From: Paul Cann
Sent: 27 November 2017 12:27
To: Planning.Responses
Subject: RE: Planning Consultation on: LU/375/17/PL

Engineers comments in respect to surface water drainage:

APPLICATION LU/375/17/PL

Description of Works: Change of use of land for the stationing of 25No. mobile
homes for permanent residential occupation

Proposed Site Layout

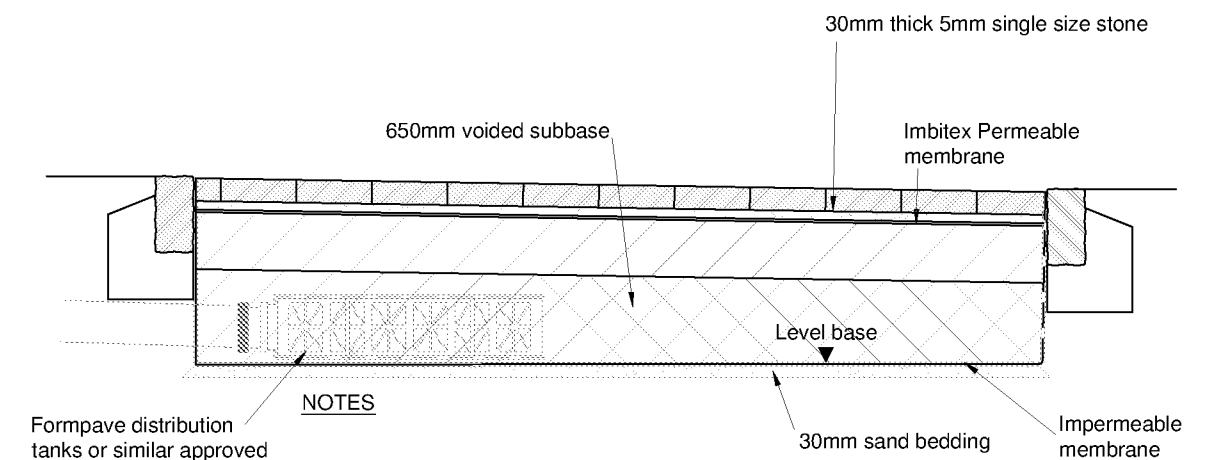
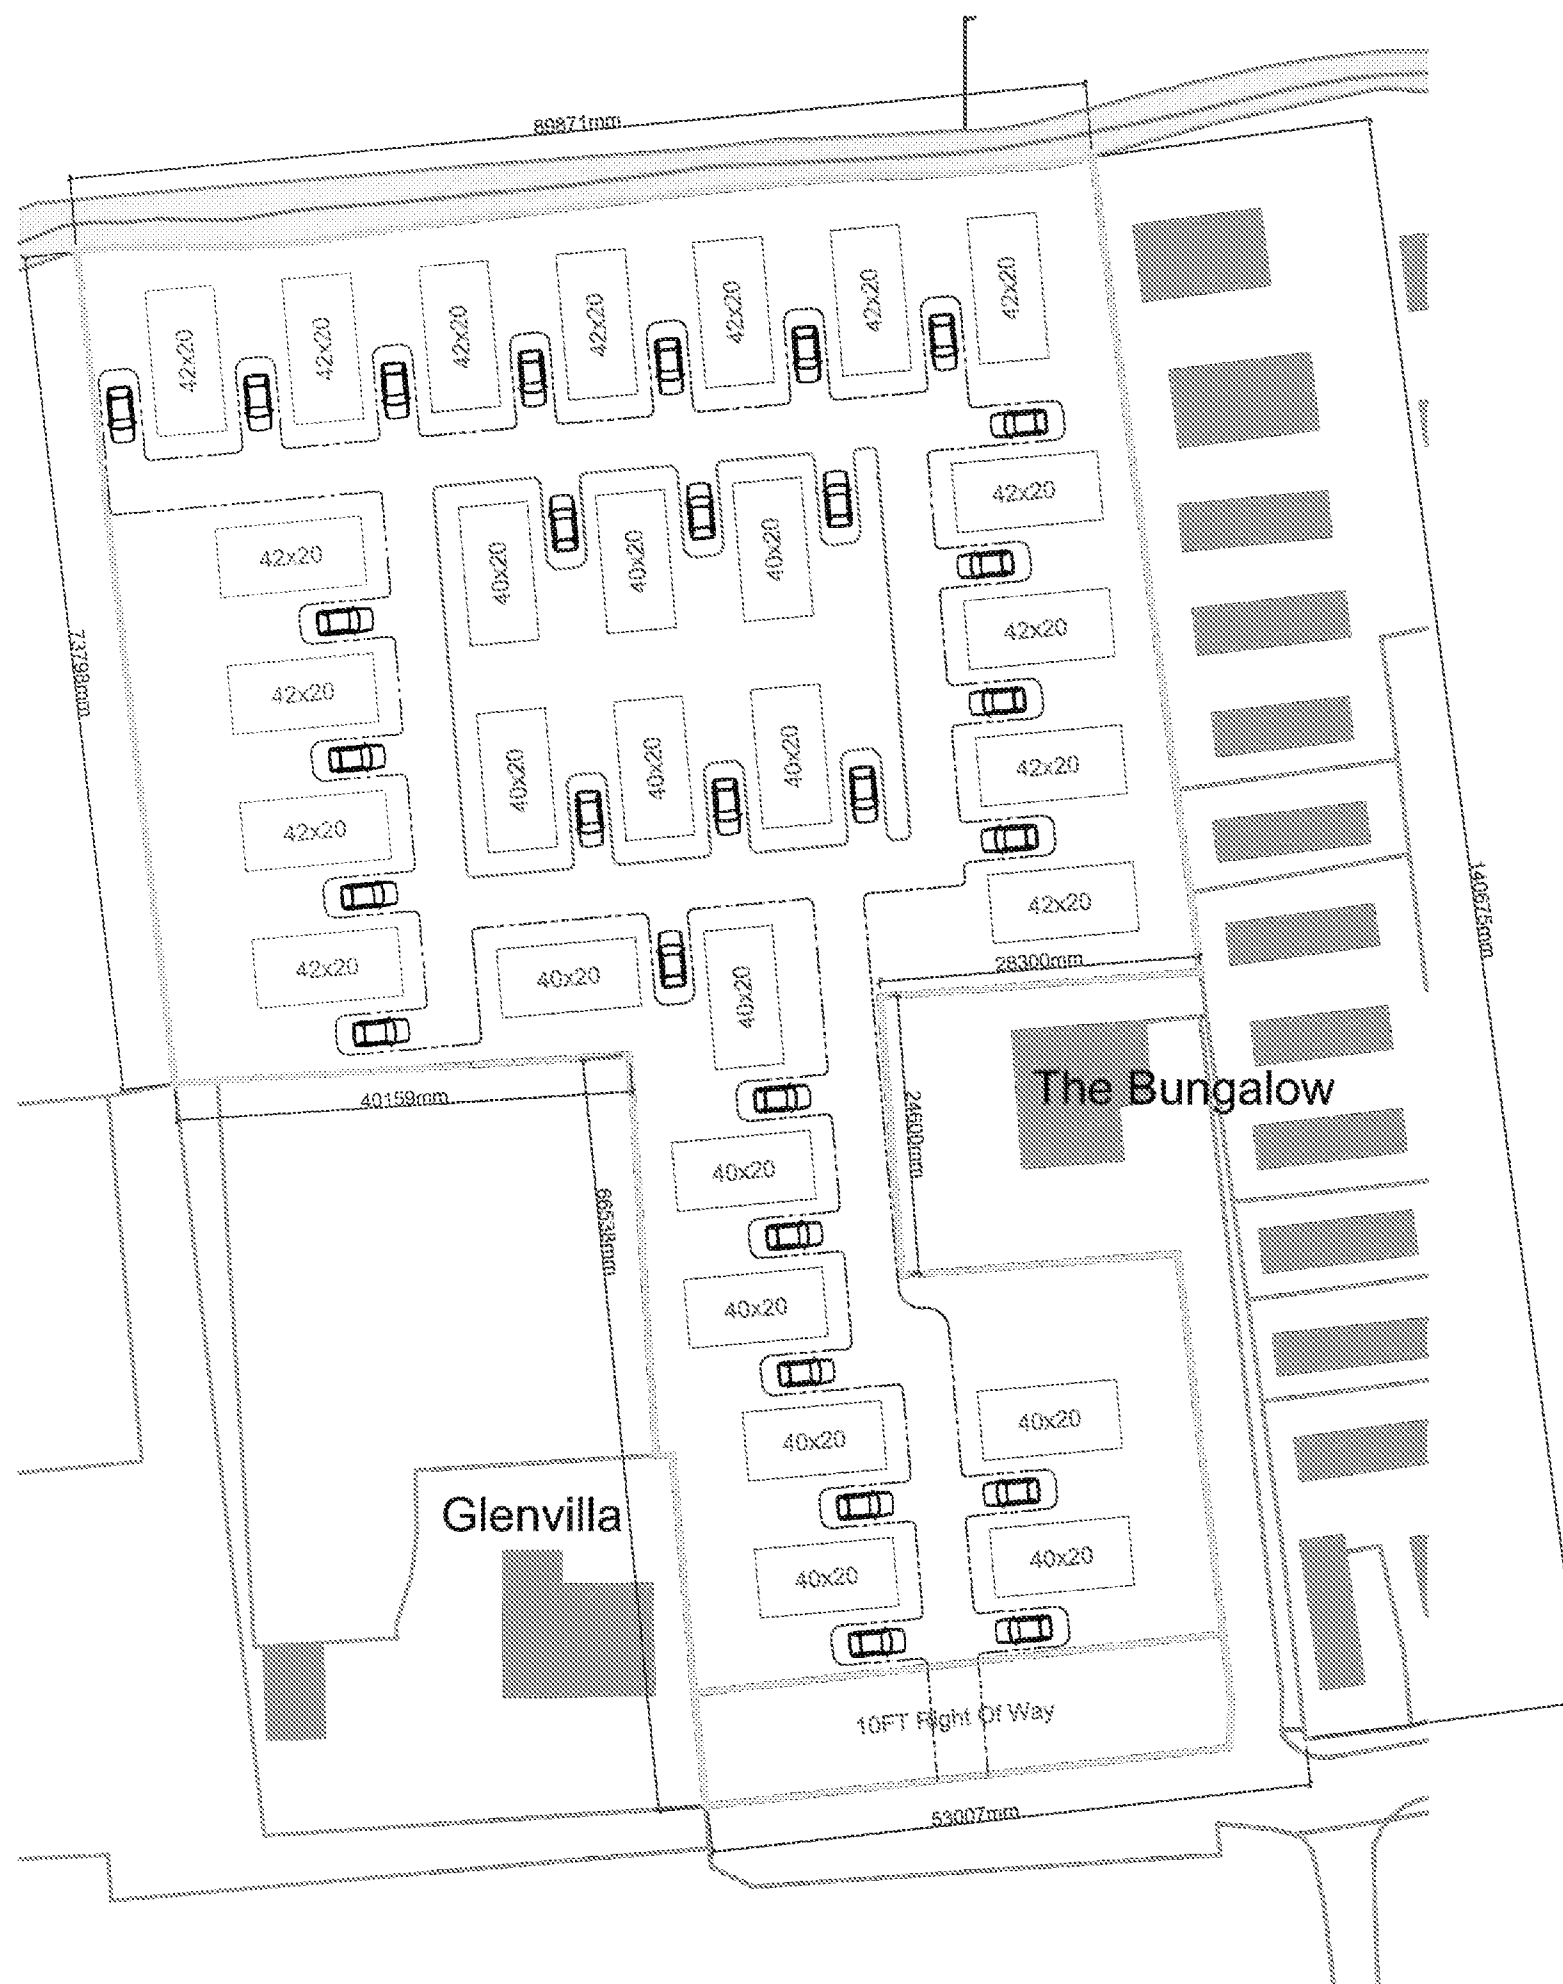
Soakaways must be fully investigated for surface water disposal, although depending on ground investigations, it is very likely that a discharge to the Black Ditch will be required, either as a hybrid scheme or possibly not.

Infiltration rates for soakage structures are to be based on percolation tests undertaken in the winter period and at the location and depth of the proposed structures. The percolation tests must be carried out in accordance with BRE 365, CIRIA R156 or a similar approved method and cater for the 1 in 10 year storm between the invert of the entry pipe to the soakaway, and the base of the structure. It must also have provision to ensure that there is capacity in the system to contain below ground level the 1 in 100 year event plus 30% on stored volumes, as an allowance for climate change. Adequate freeboard must be provided between the base of the soakaway structure and the highest recorded annual groundwater level identified in that location.

Any SuDS or soakaway design must include adequate groundwater monitoring data to determine the highest winter groundwater table in support of the design. Supplementary guidance notes are also enclosed for information.
